Application Reference: LU/157/26/PL

Site: WICK FOOTBALL CLUB, CRABTREE PARK COOMES WAY BN17 7LP

Proposal: Change of surface from grass to artificial turf and erection of new 2.5m acoustic fencing. Is in CIL Zone 2 (zero rated) as all other development.

Sport England Reference: PA/26/SE/AR/74592

EDGE DETAIL

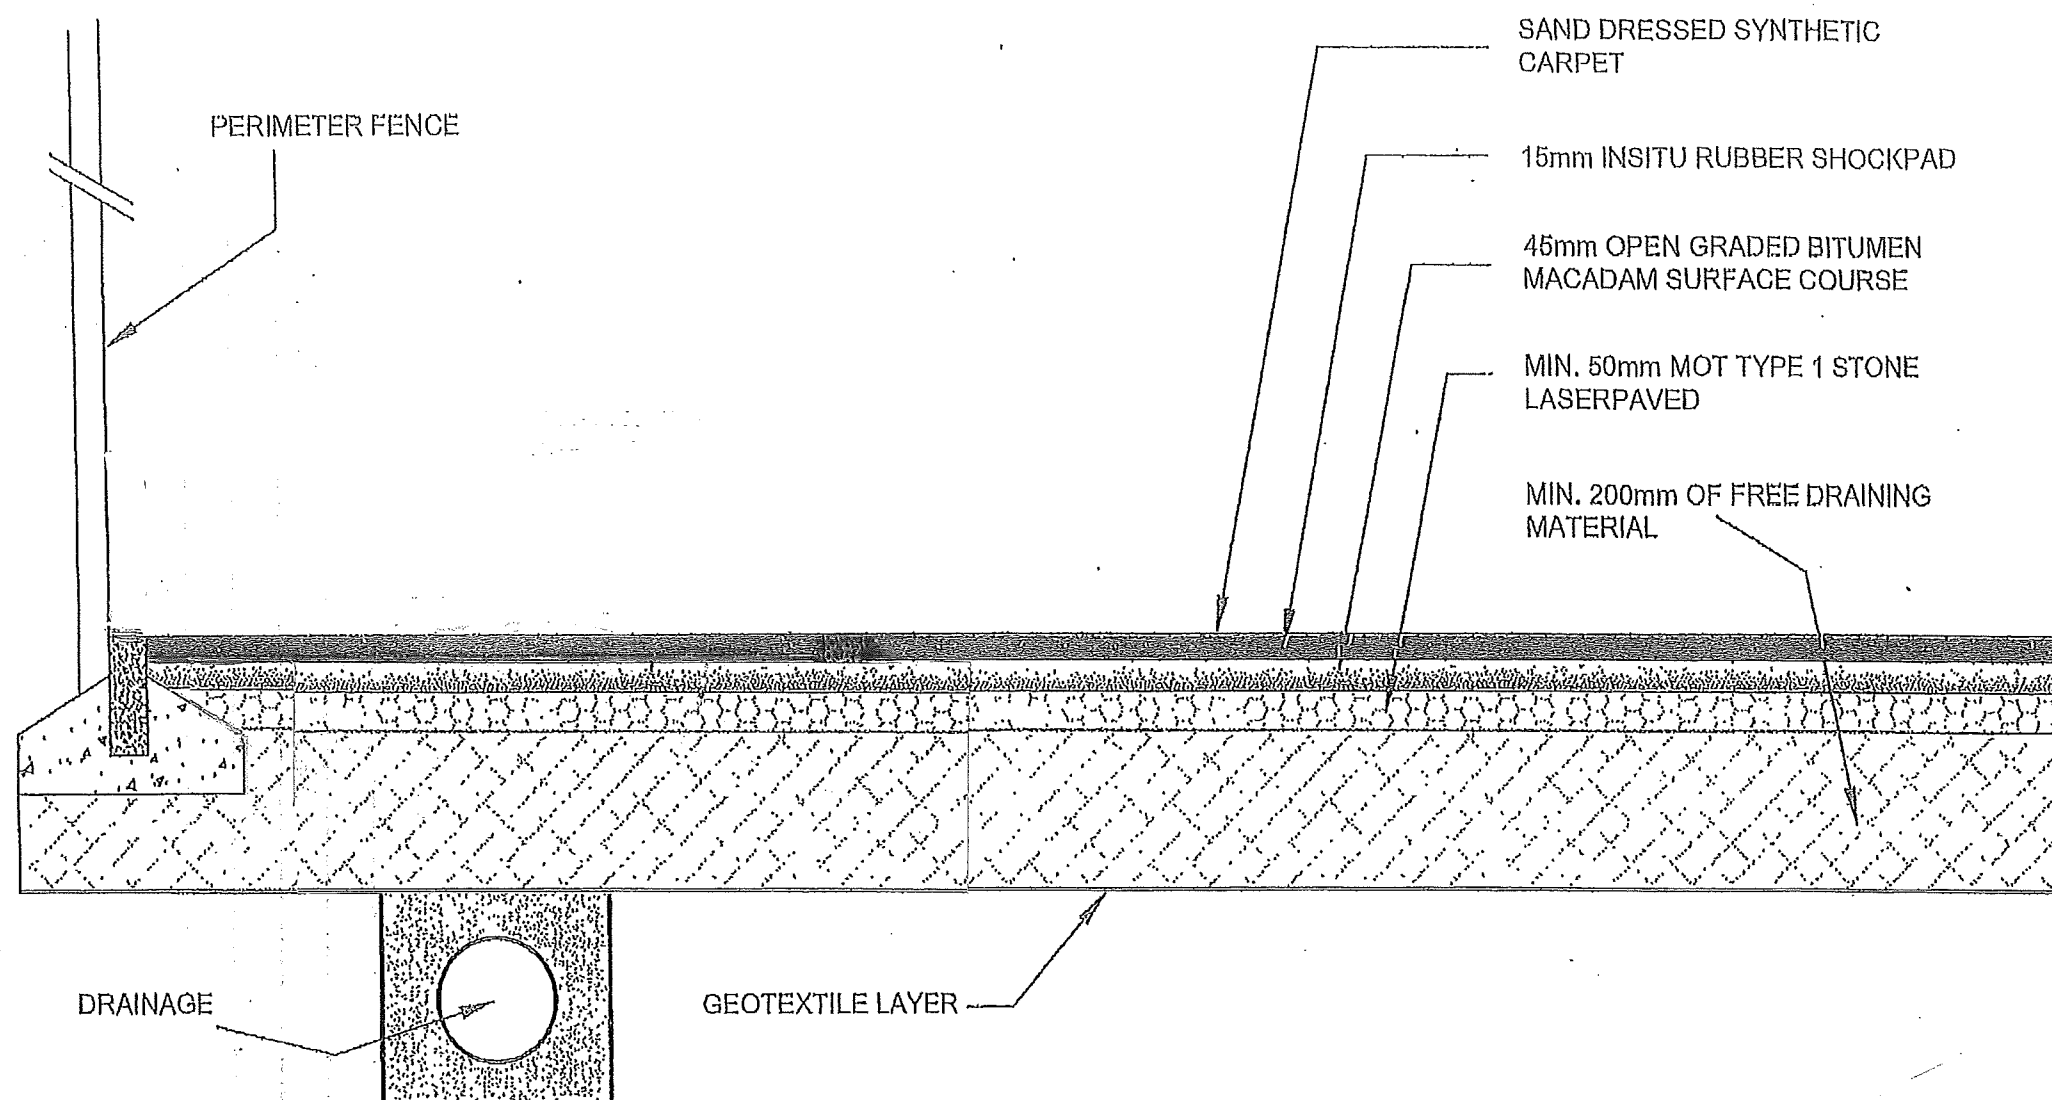
- *The document listed- Edge Detail Plan Dwg no. 2230/04- references that the 3G will be sand-dressed. This contradicts other documents.*
- *The document listed- Proposed Site Layout Dwg no. 0001- show padel courts in the car park, with no reference to this in the D&A statement or other documents. We are concerned that this will restrict the limited car parking on site. We do not support these plan with the current level of information provided.*

PROJECT NO.	SOFTWARE	DISCIPLINE	DRAWING NO.	REVISION NO.
SCS25094	DWG	LP	0001	00
SCALE	SIZE	DRAWN	CHECKED	
1:300	A1	PB

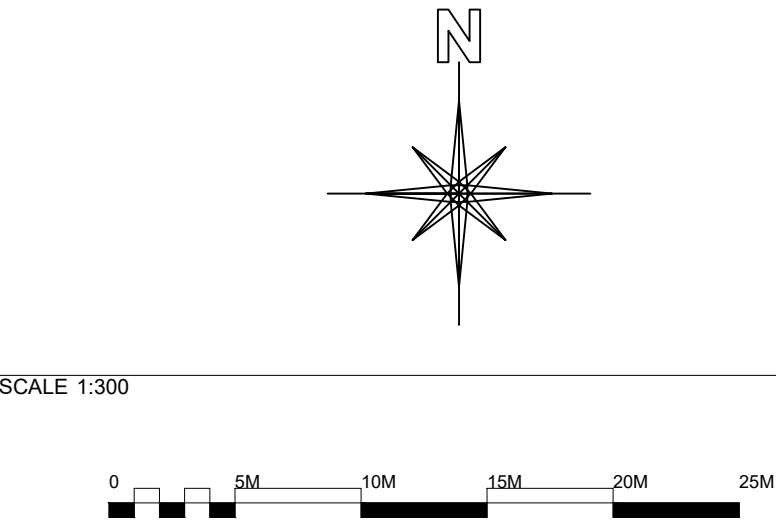
It notes in the Planning Statement that the council were concerned that parking may be an issue given the increase in use of the site due to the artificial pitch, however the proposed site layout drawing shows 3 padel courts located in the parking lot. Is padel being delivered as part of this application? This has not been stated in the Planning Statement and no design information has been provided.

- 1) Are padel courts being delivered and if so, please provide design details for these courts
- 2) What is the surface that is being delivered and what sports are being accommodated. If this is to be for rugby and football then the surface needs to be world rugby compliant as well as FIFA compliant.
- 3) All of the other questions raised from the Football Foundation under Technical Detail should also be addressed.
